Summary of Natural England's Written Representations advice in respect of A46 Coventry Junctions (Walsgrave)

Appendix 8.16 Assessment of Noise Impacts on Ecological Features

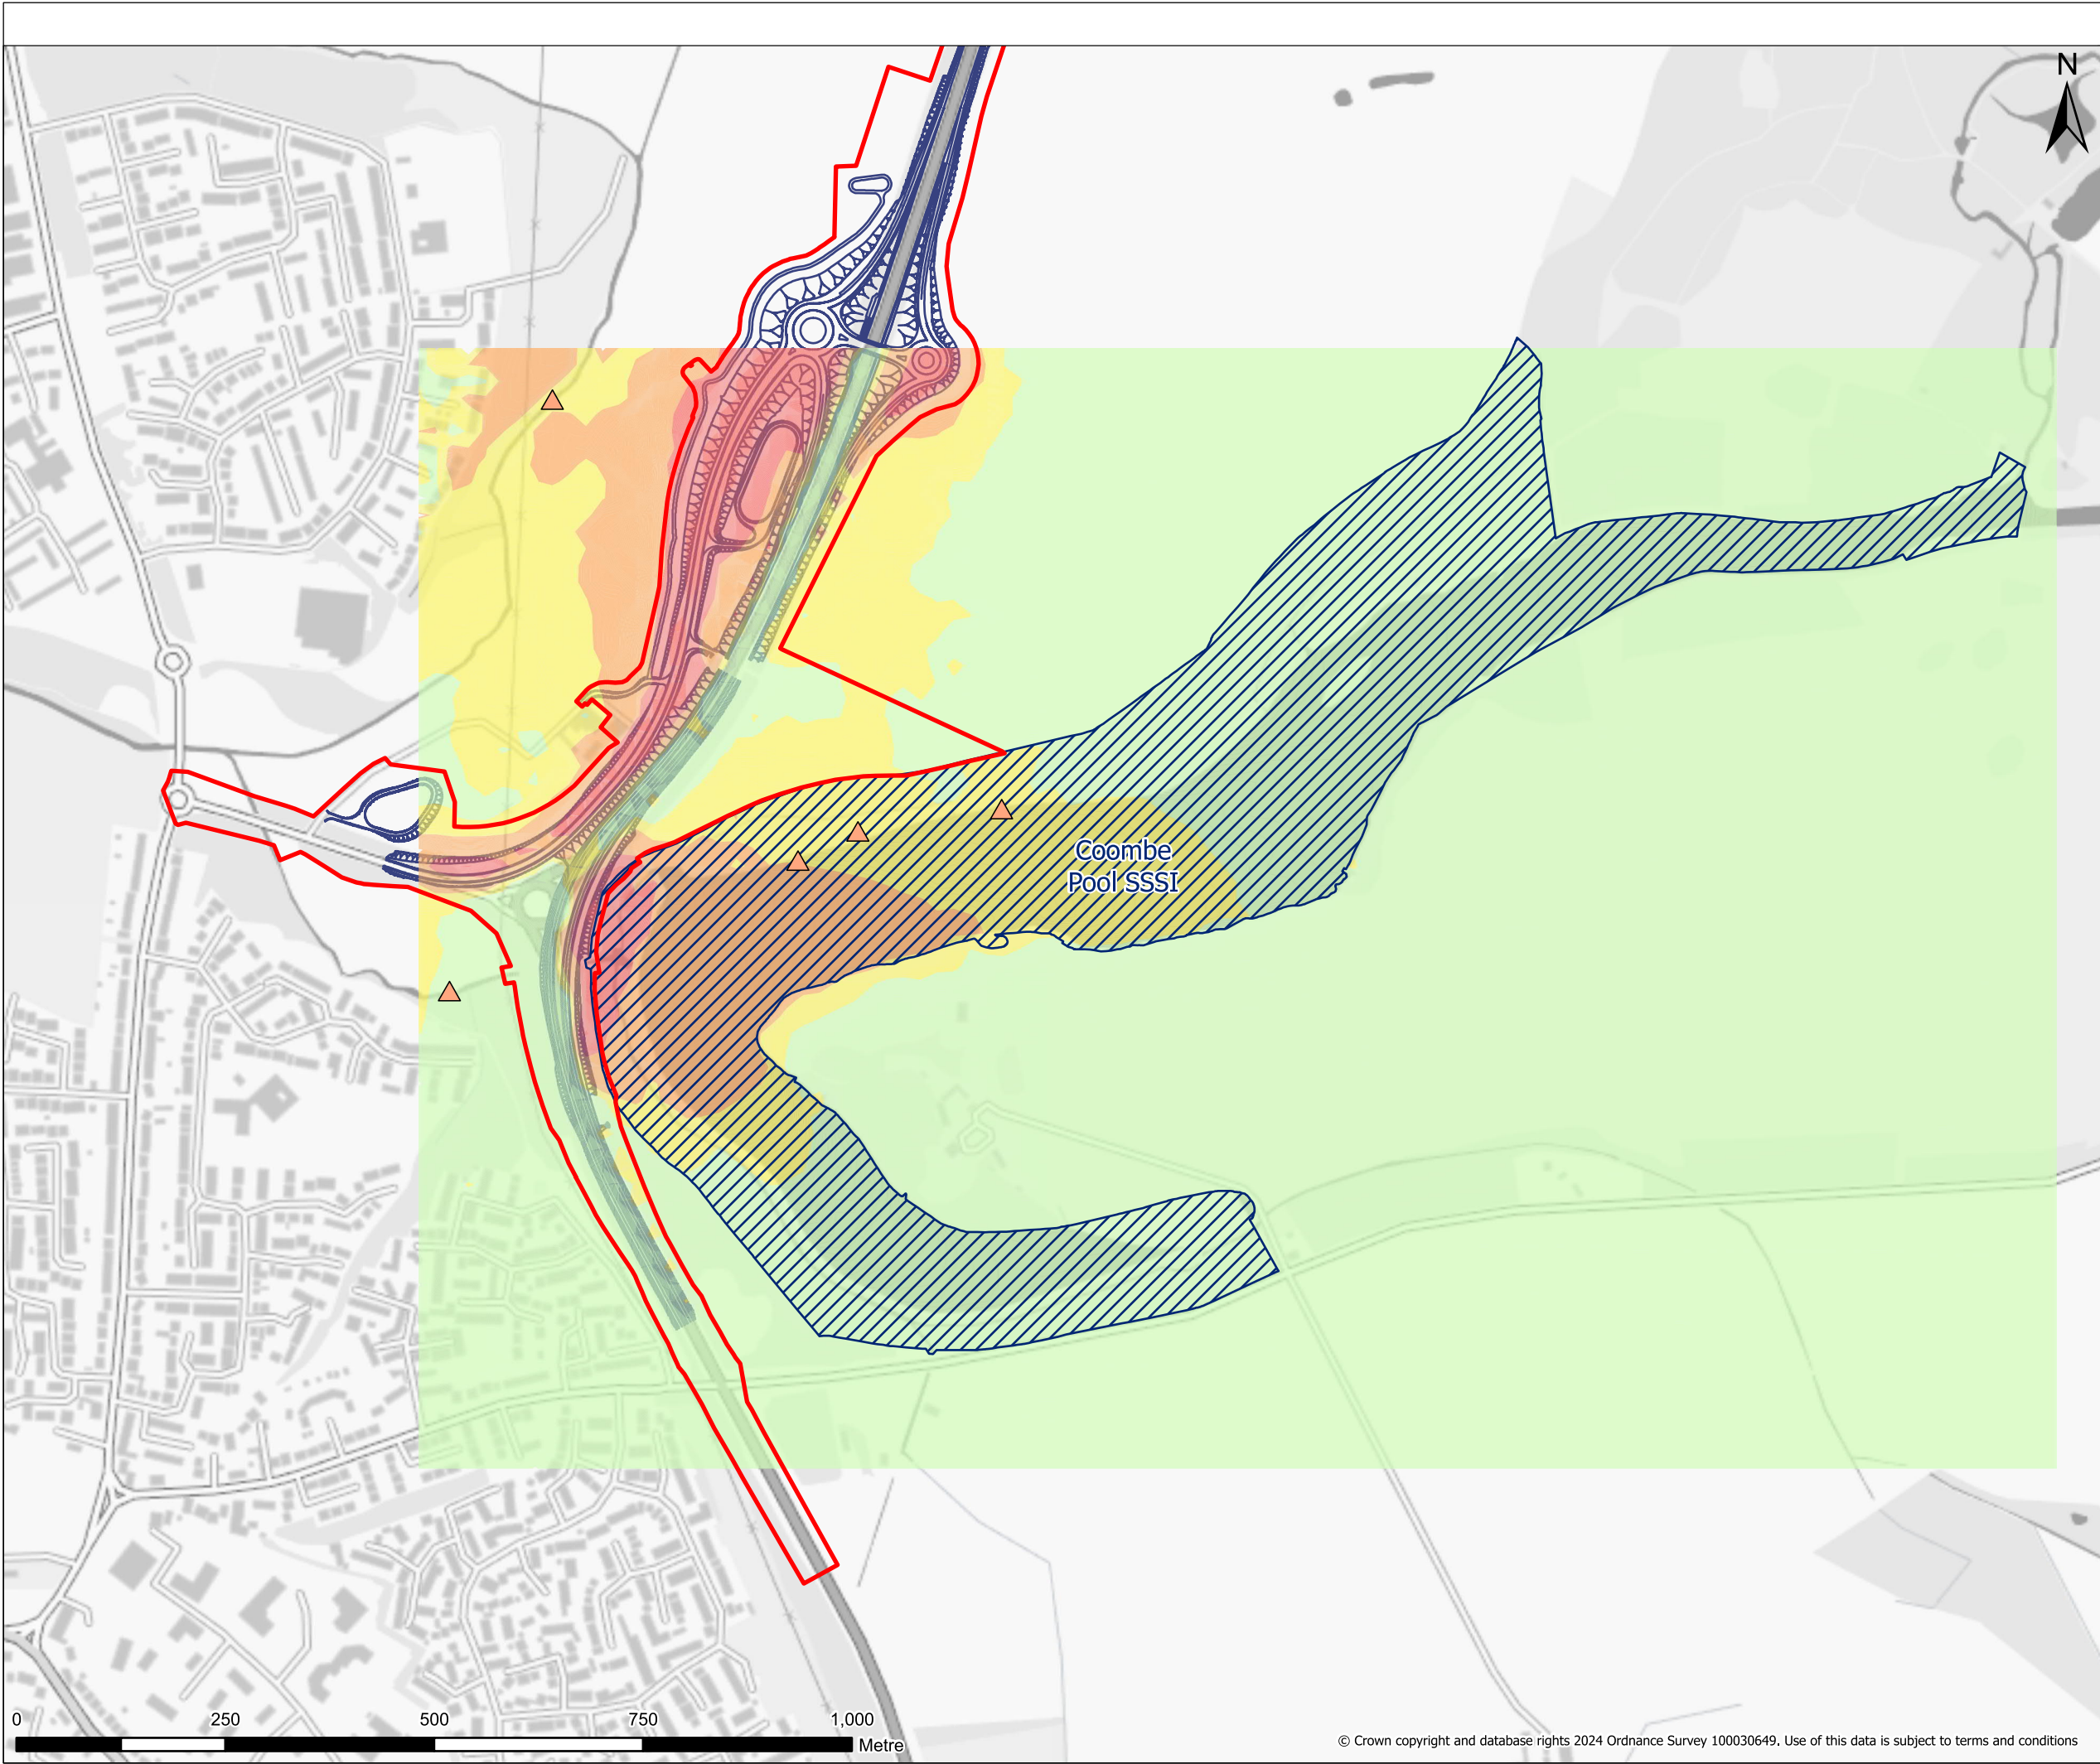
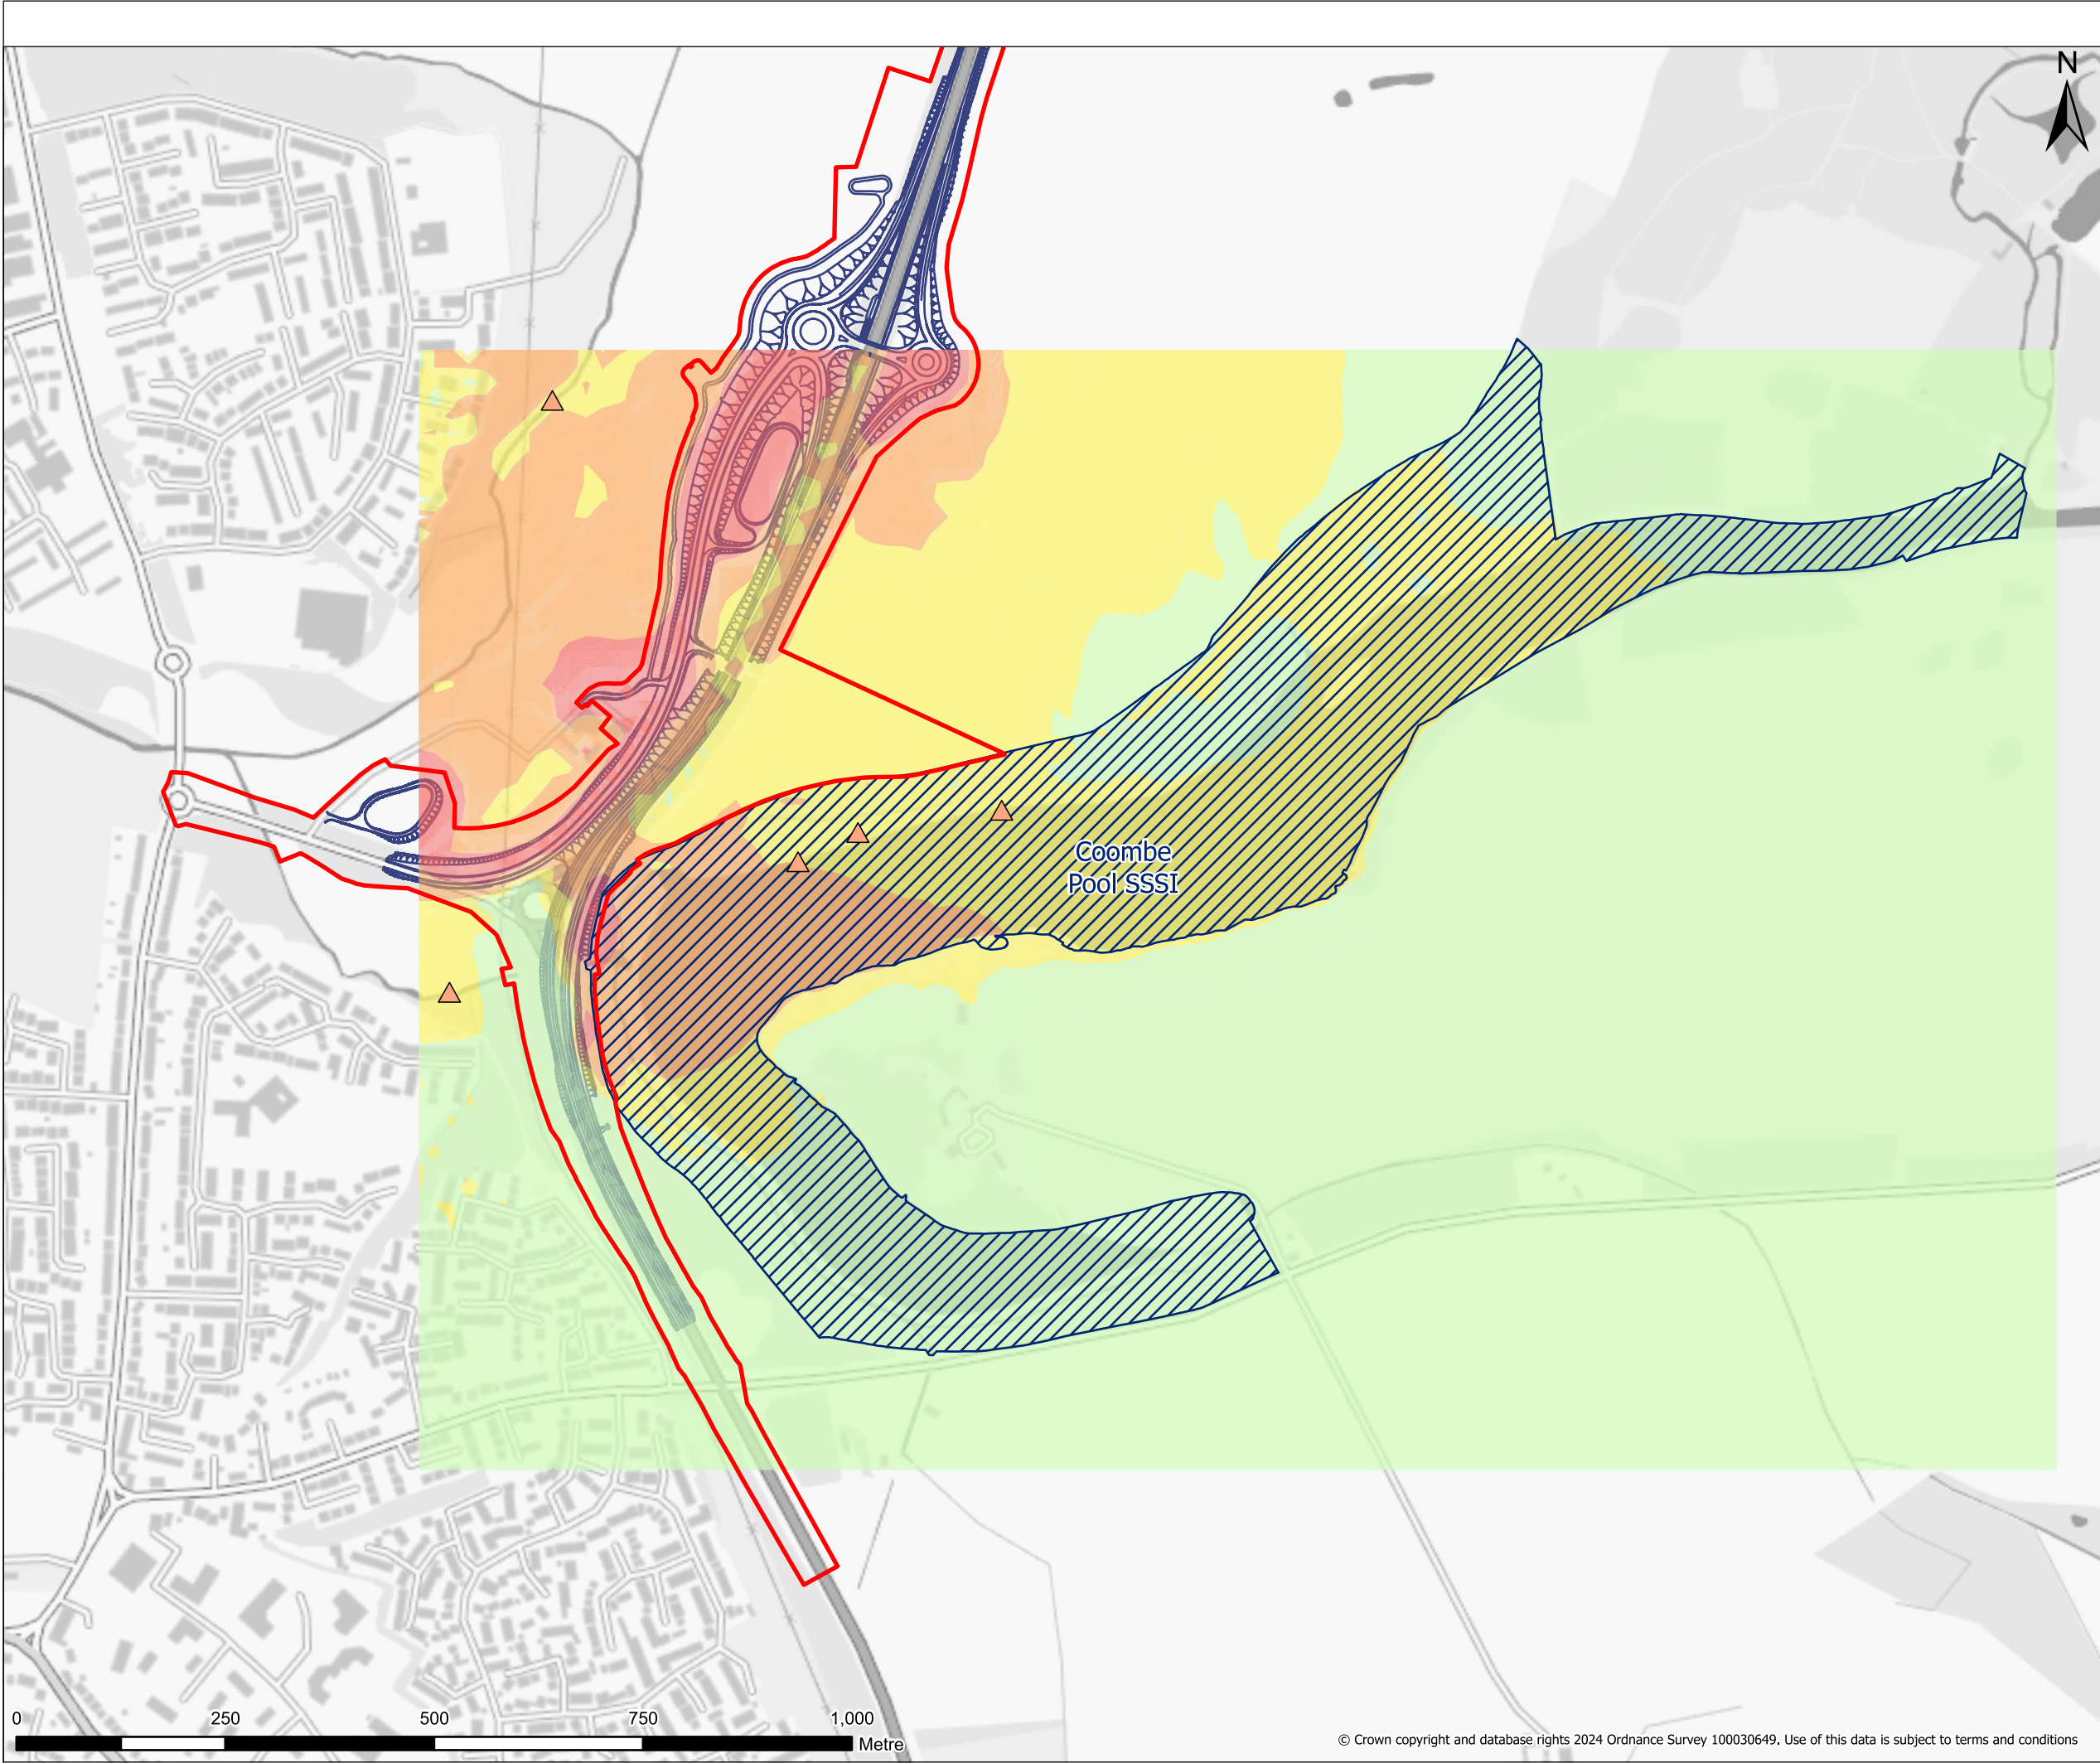
- Impacts of noise and lighting on Combe Pool SSSI and mitigation to prevent impacts (NE4).
- Impacts from air quality (NOx, NH3, N dep) on Combe Pool SSSI and Herald Way Marsh SSSI (NE6).
- Impacts on water quality and water quantity on Combe Pool SSSI and Herald Way Marsh SSSI (NE7).
